FULL

Reference: H16-0138-18 **Date of Decision:** 10th April 2018
Applicant: Savers Health & Beauty
Unit 1, Prologis Park
Arenson Way
Dunstable
LU5 4RZ

Location: 20 - 21 Hall Place Spalding
Description: Proposed new shop front

SAVERS - SPALDING SHOPFRONT
L1

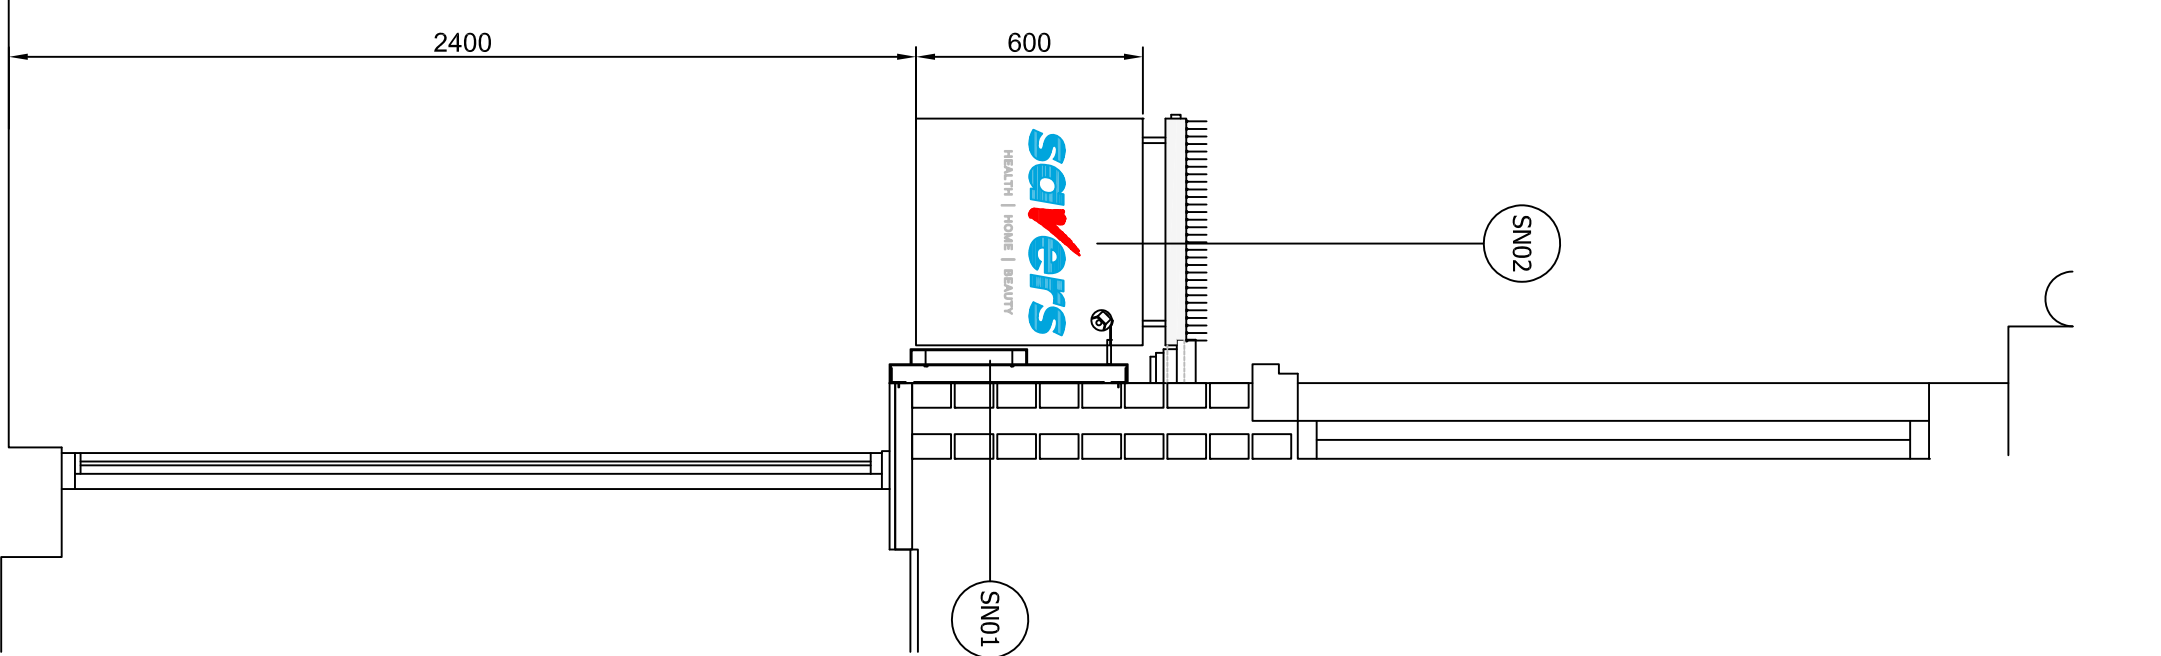
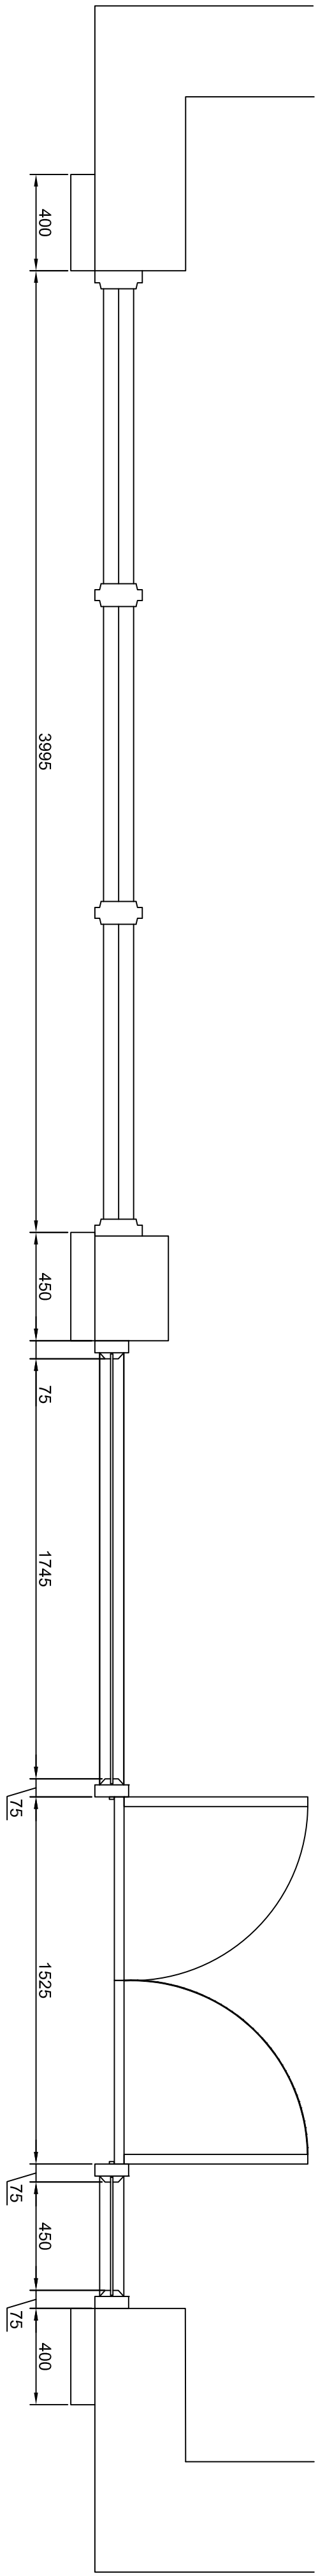
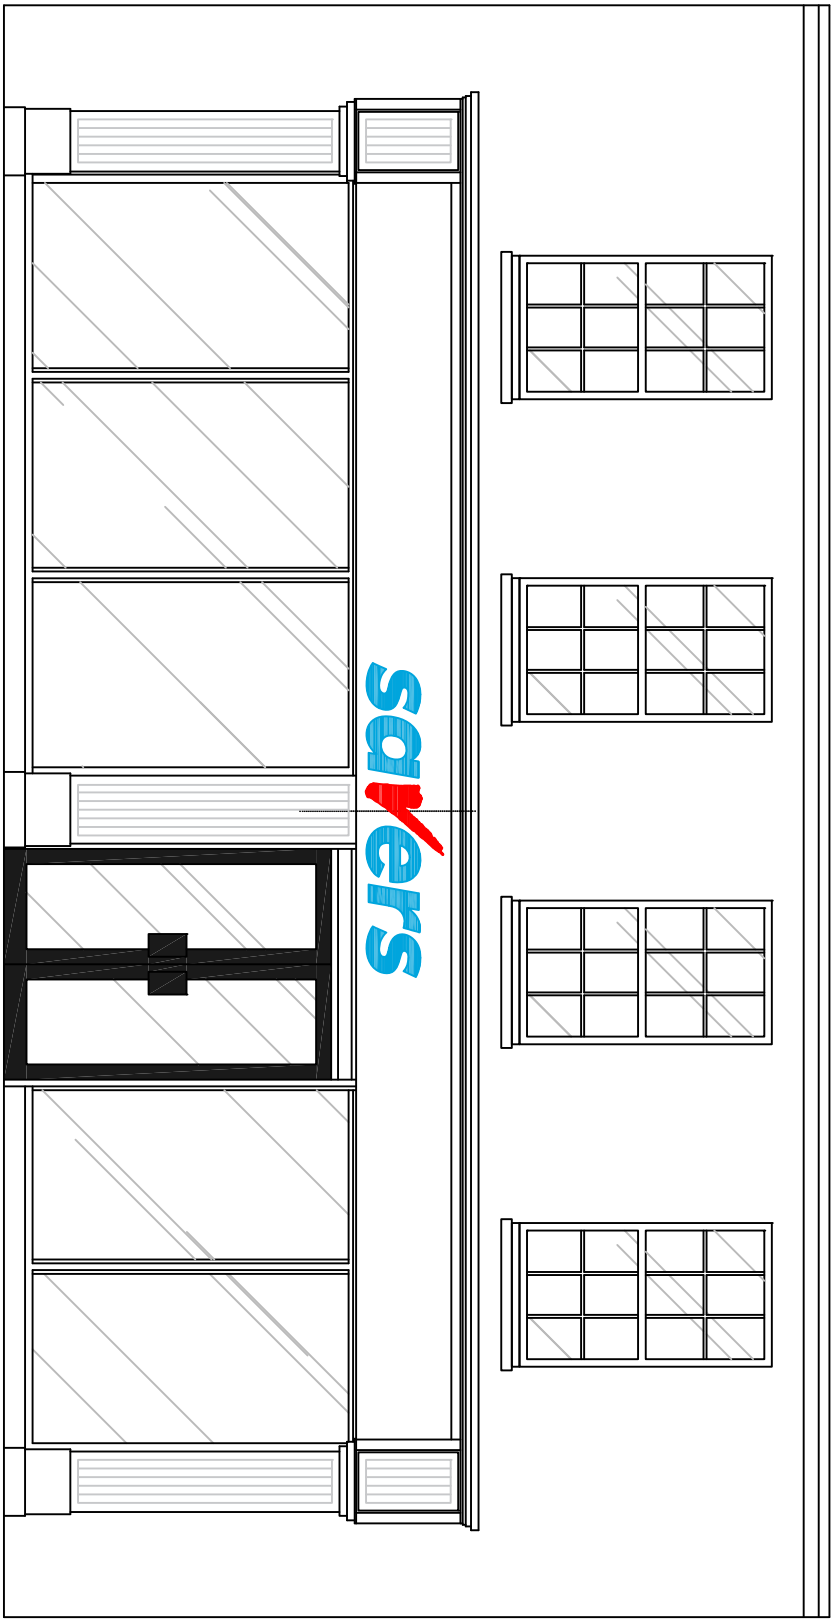
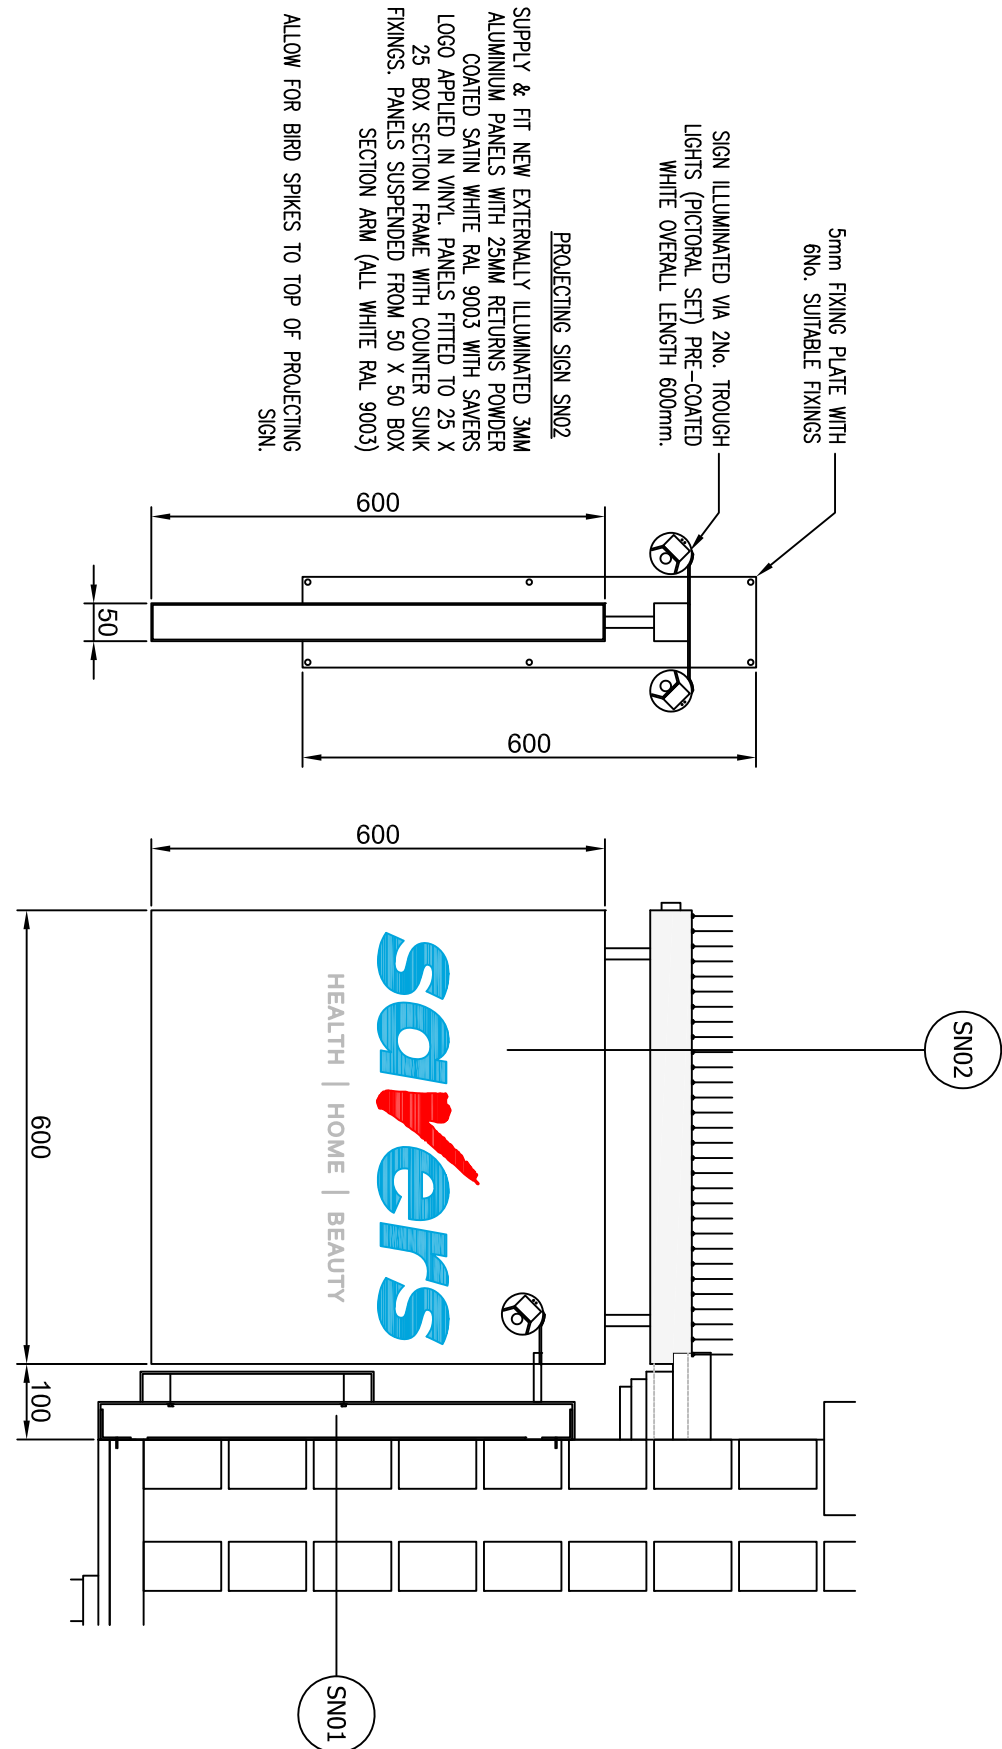
- 1 The proposals are inappropriate to the character of the 19th Century building. It does not positively contribute to the preservation of the Conservation Area and if approved, would set an unacceptable precedent for other adjacent buildings.

The proposed over-cladding of the shop front pilasters would dilute a prominent traditional feature and introduce a contemporary design in the Conservation Area.
